From: Sue Howell
Sent: 30 August 2017 17:18
To: Planning.Responses
Cc: Anita Gardner
Subject: RE: Planning Consultation on LU/177/17/DOC

Comment from Greenspace

Condition 3 Landscaping scheme – Further to submission of DWG No 5312-LC-100 Landscape Masterplan, DWG No 5312-LC-401/405 Rev B we comment as follows:

Site Address: Littlehampton Swimming & Sports Centre Sea Road Littlehampton BN16 2NA

DWG. NO 5312_LC_403_REVA

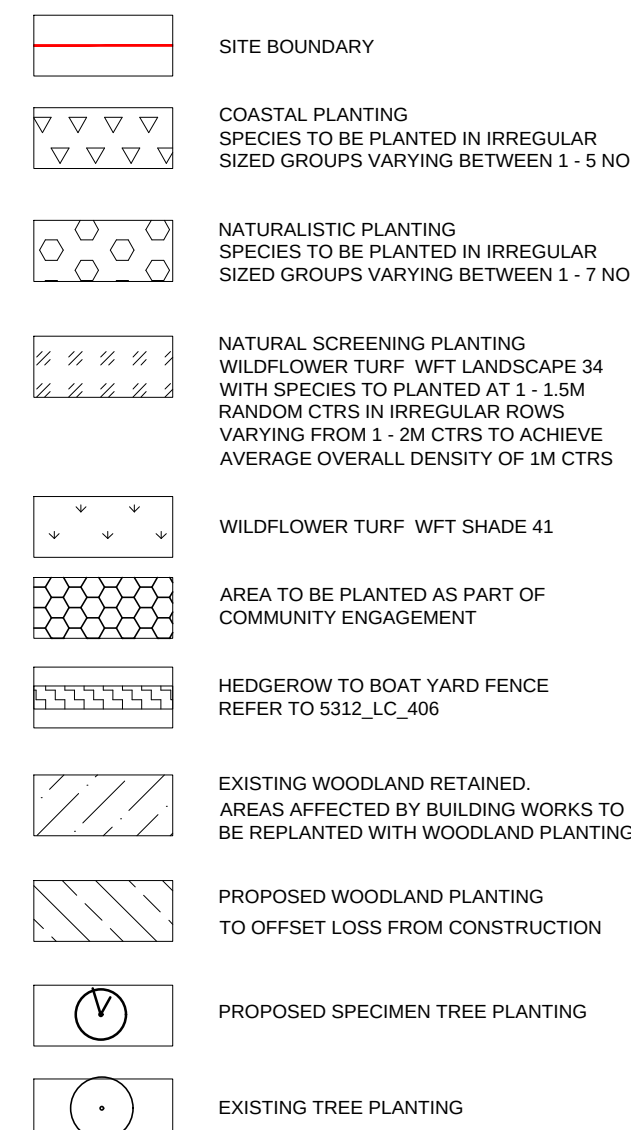
- Consideration has now been given to the tree species choice in the Sea Road and Hendon Avenue locations which are full exposure locations. The tree mix here has now been amended to reflect this and *Populus alba* specified rather than *Betula* for these locations.

- Amenity grassland is now specified to achieve high amenity areas where close mown grass areas will be more suitable. The areas shown for 'natural screen planting' of native shrubs now amended to be planted into cultivated and mulched planting beds rather than the previous amenity grassland. Species rich grassland areas increased to the rear of the centre which will aid in the off-set the loss of semi –improved grassland types both in terms of area and plant diversity.

- The Ecological review of Landscape Strategy states 'loss of mixed woodland is temporary and will be compensated through additional woodland planting along the east boundary of the site' Several blocks of native mixed planting have been identified for inclusion into the scheme to the north/east of the new building and into Mewsbrook Park.

- Clarification has been given regarding the proposals for the rear of the new centre, which are shown as species rich grassland and existing woodland scrub and hedgerow to be retained. These areas could potentially be enhanced and improved and may be the subject of further detail and enhancement proposals in the future. These areas over time will marry with the retained existing woodland scrub, shrub and hedgerow planting.

Following this revised submission **we would now recommend the discharge of condition 3** imposed under LU/314/16/PL on this application LU/117/17/DOC.
